TAMWORTH REGIONAL COUNCIL SUBMISSION – STATE SIGNIFICANT DEVELOPMENT – TANGARATTA FEED MILL (SSD-58801472)

I refer to your correspondence received 09th October 2024 regarding the public exhibition of a State Significant Development, being the Tangaratta Feed Mill (SSD-58801472). Please find Tamworth Regional Council's comments on the proposal below.

DRAWING TITLE: **SWEPT PATH ANALYSIS - SITE ENTRY NORTH & SOUTH (A-TRIPLE)**
 CLIENT: **BAIADA POULTRY**
 PROJECT: **TANGARATTA FEED MILL**
 LOCATION: **771 WALLAMORE ROAD, WALLAMORE 2340 NSW**

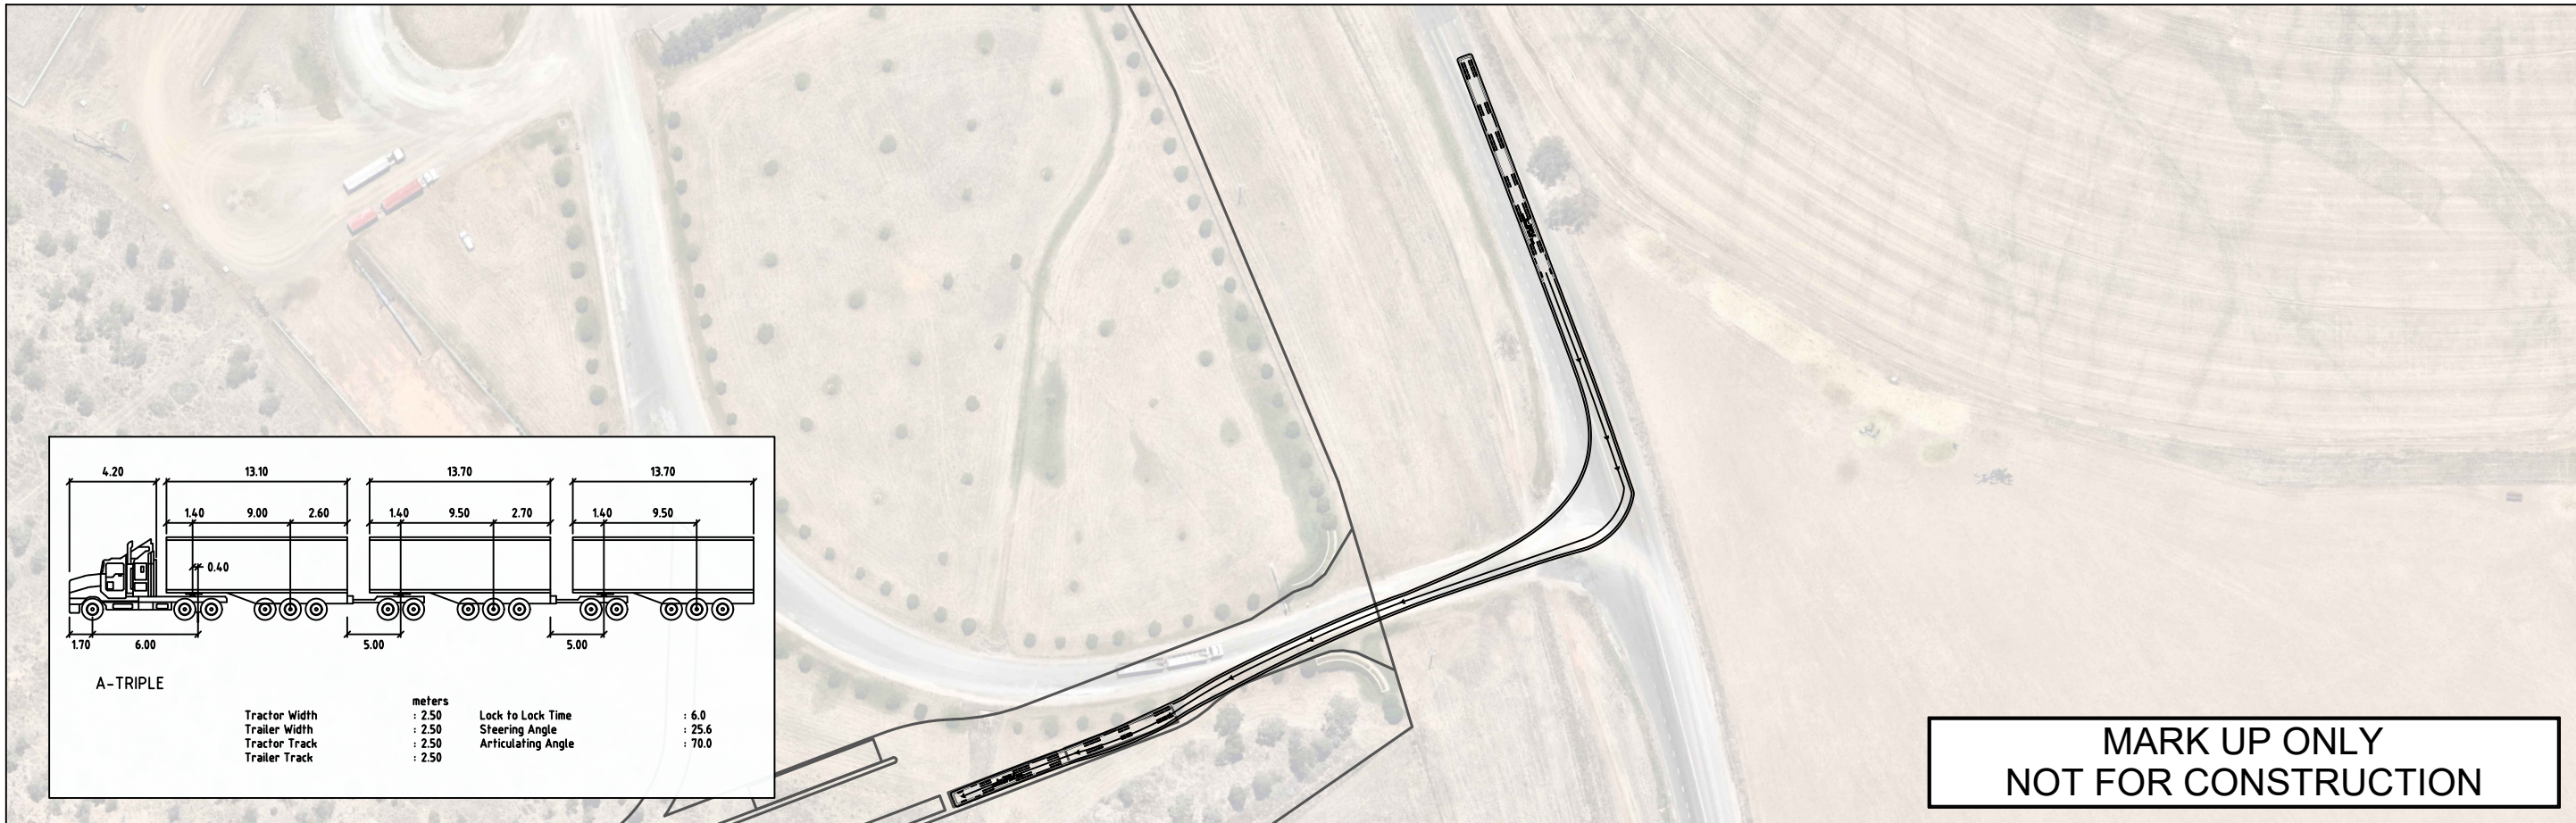
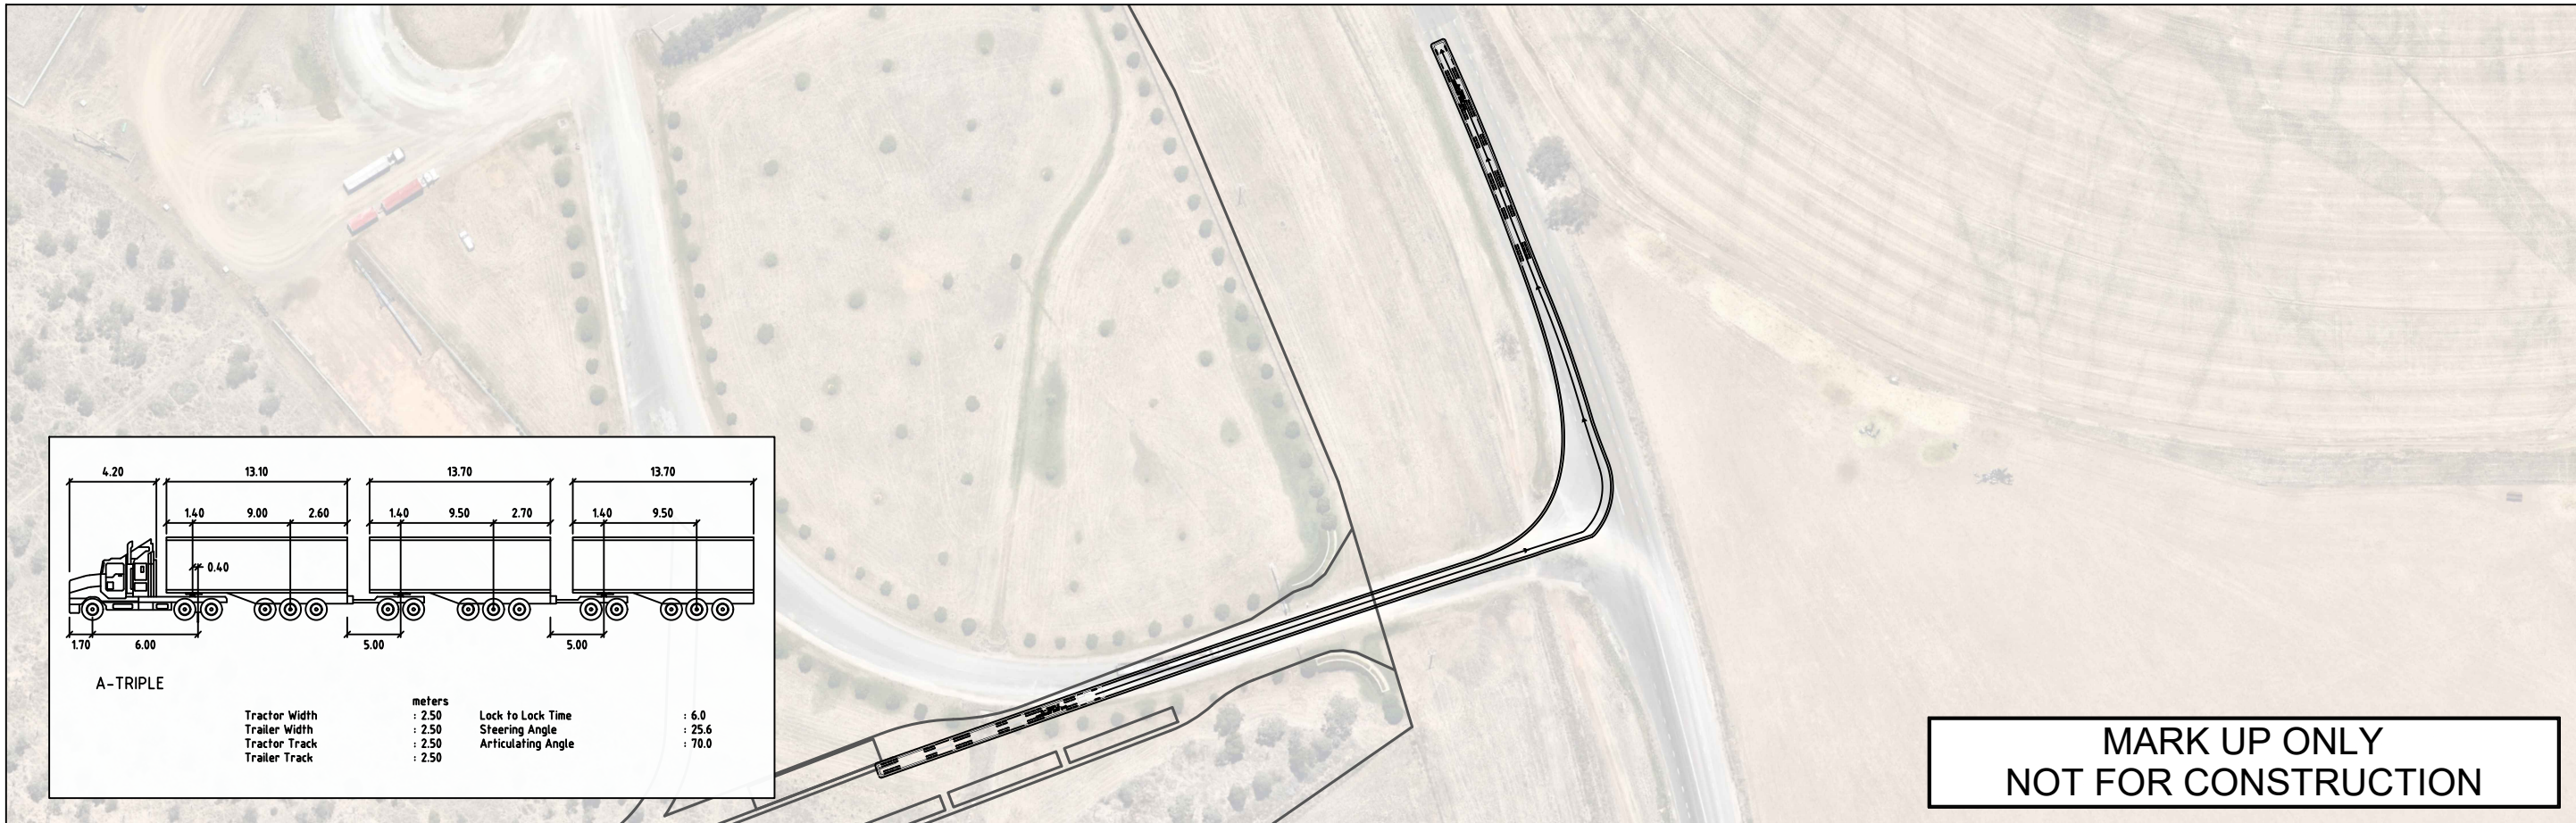
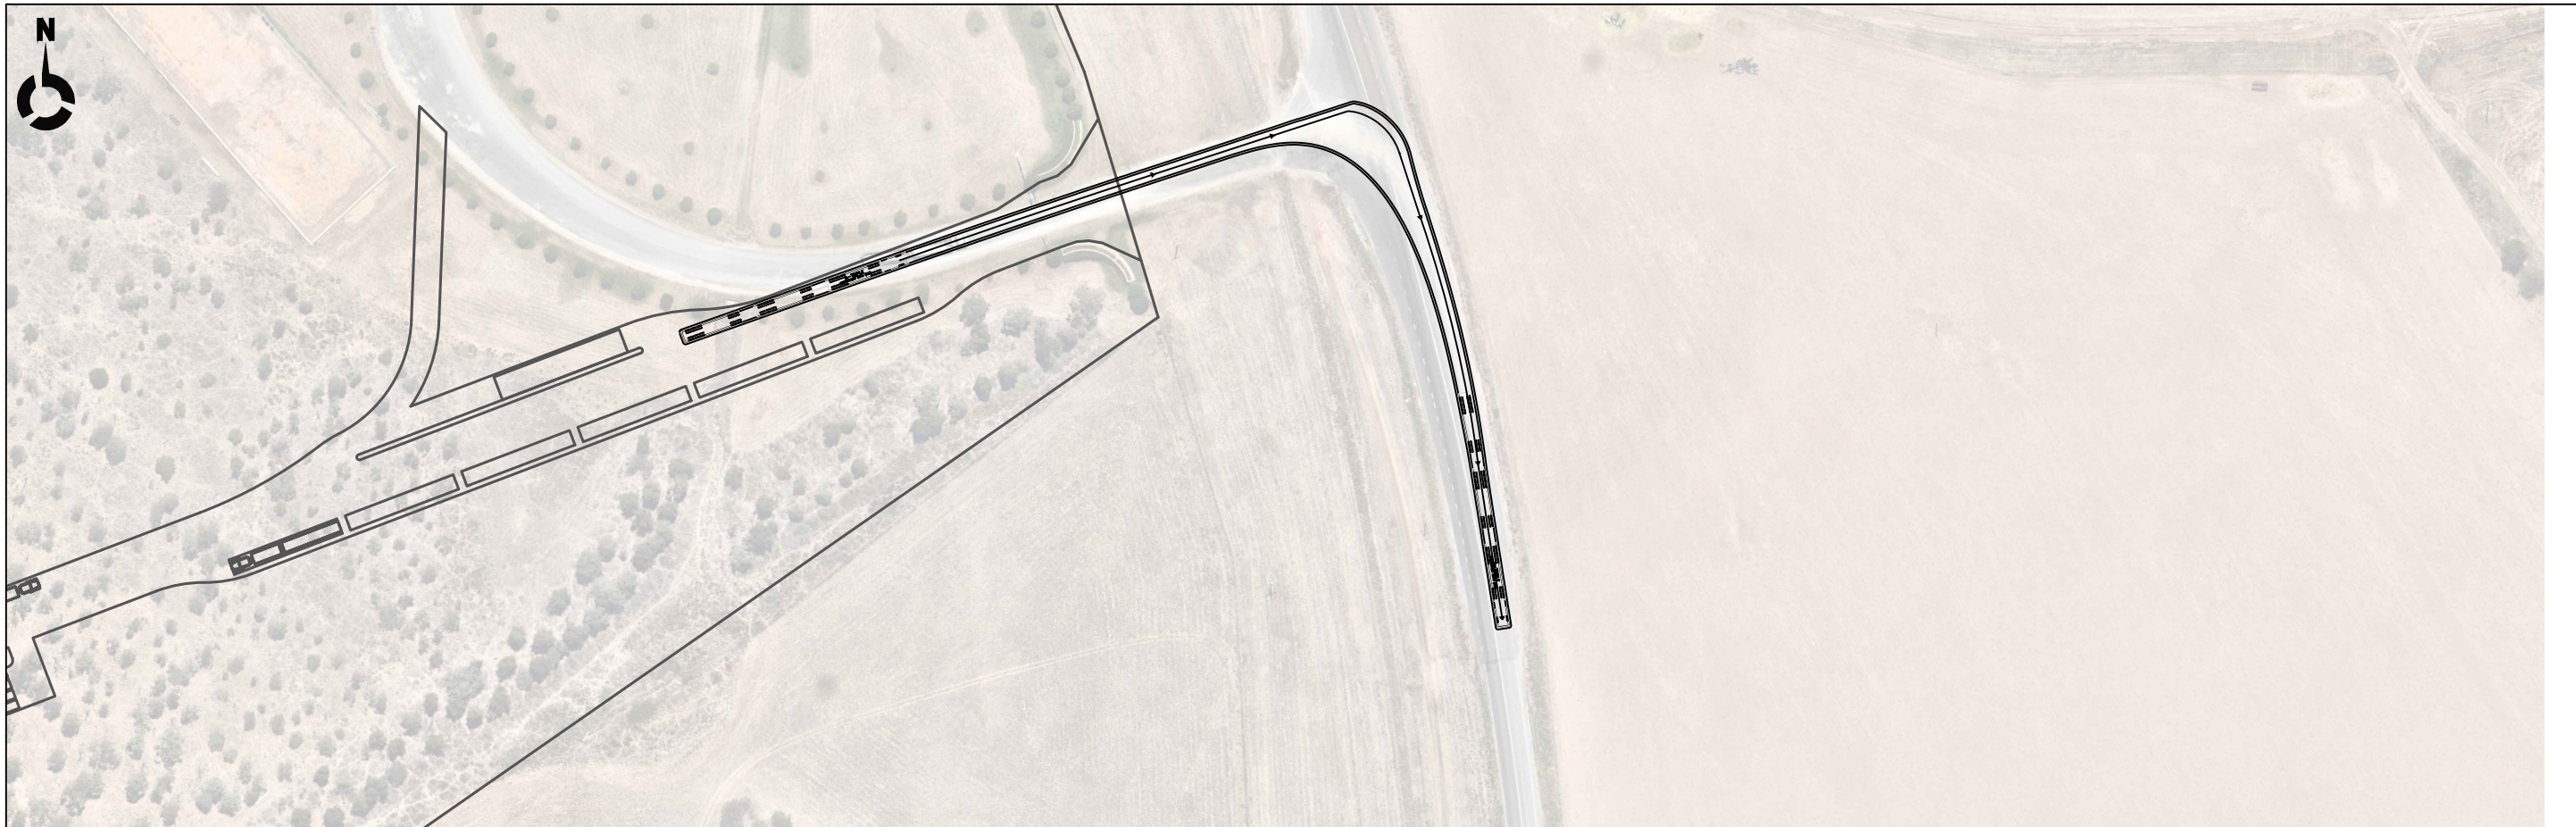
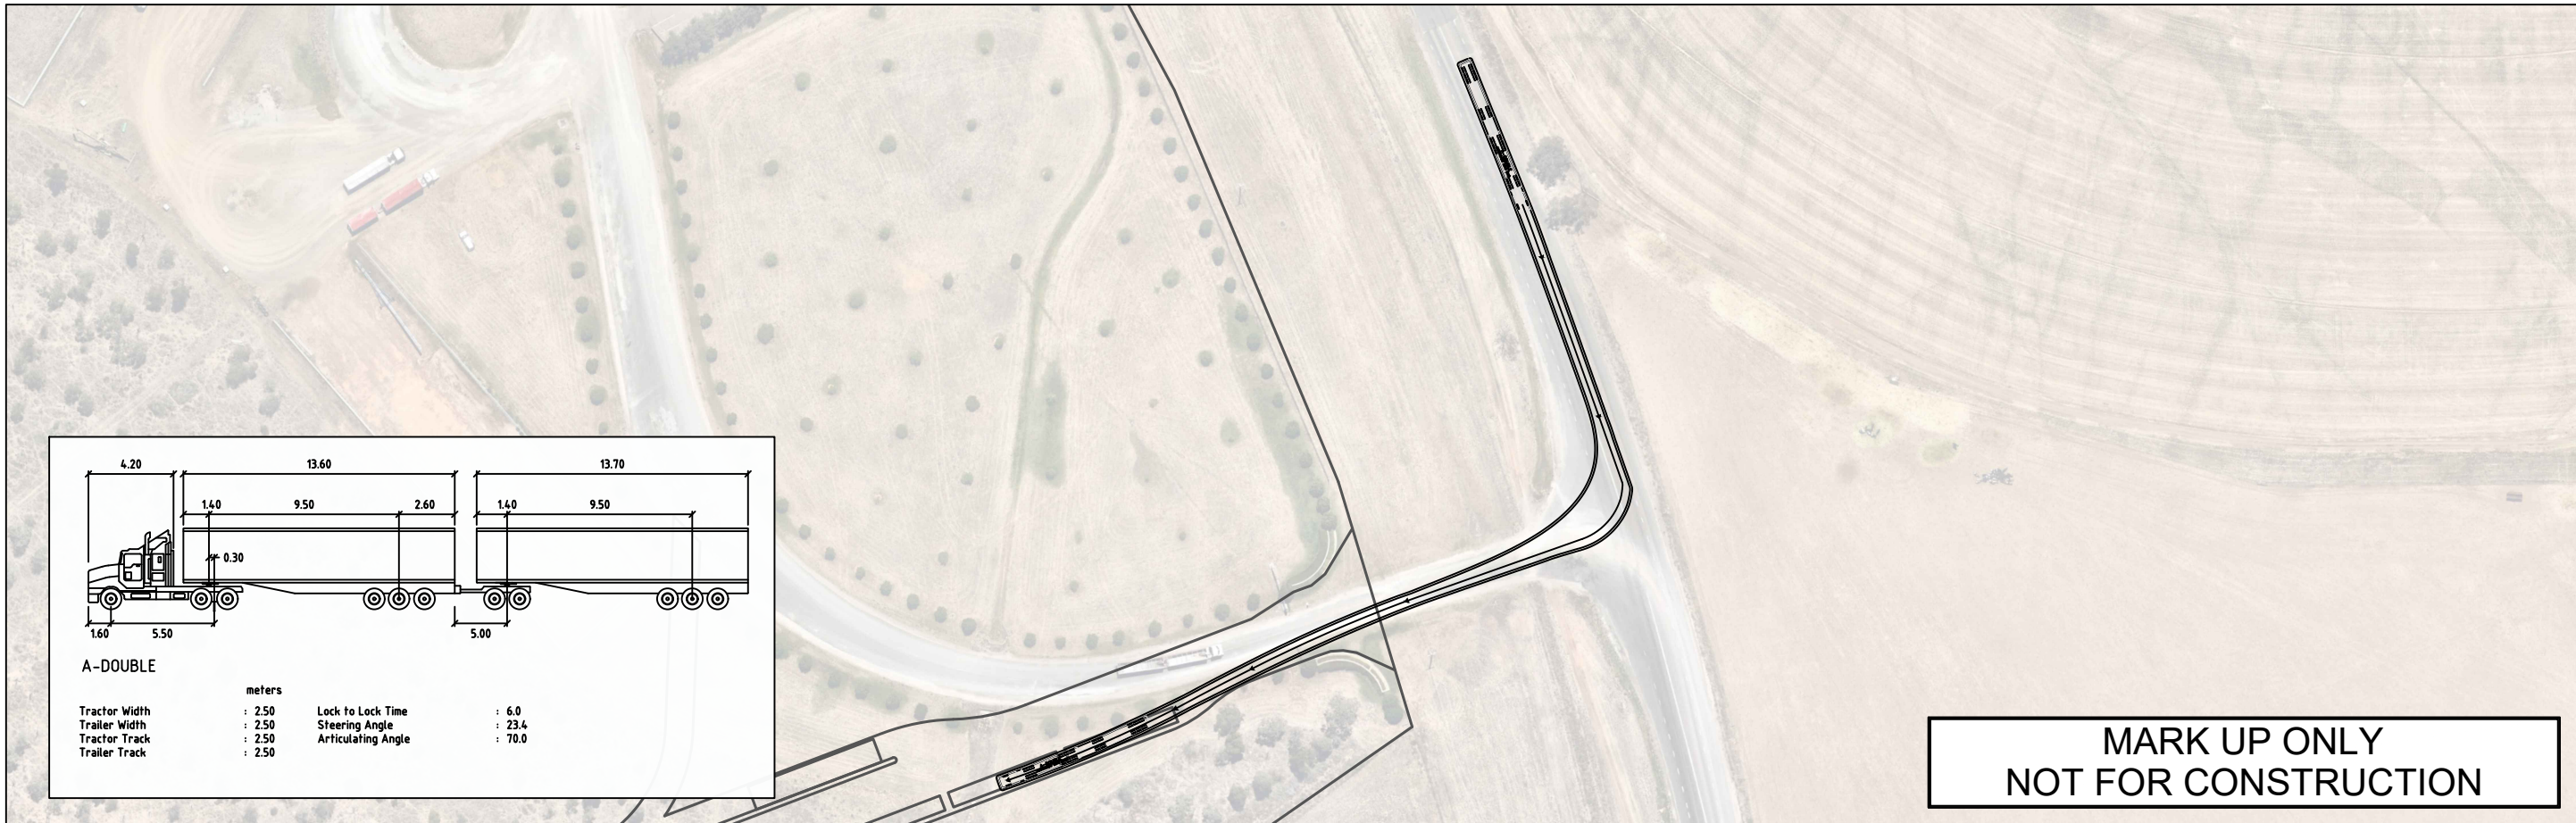
Council has reviewed the Traffic Impact Assessment (TIA) for the proposed development. Based on the review, it is identified that Wallamore Road is currently not gazetted for vehicles larger than a B-Double, while the Oxley Highway is approved for B-Triple and AB-Triple vehicles, and conditionally approved for A-Double vehicles. Should the applicant intend to access the site with vehicles larger than a B-Double, a route assessment must be prepared according to NHVR requirements for the "last mile" of the proposed transport route, specifically covering Bowlers Lane and Wallamore Road.

Deceleration and acceleration distances, along with BAL/BAR turn treatments, must be assessed for the largest intended vehicle at the site access and at relevant intersections along the transport route. Further, the site access should be designed to permit the largest vehicle to enter the site while an exiting vehicle holds before Wallamore Road.

Furthermore, the access must be widened with pavement of suitable depth to accommodate the swept path of the largest vehicle, and it should be sealed to ensure all-weather access and to prevent soil or loose gravel from being tracked onto Wallamore Road.
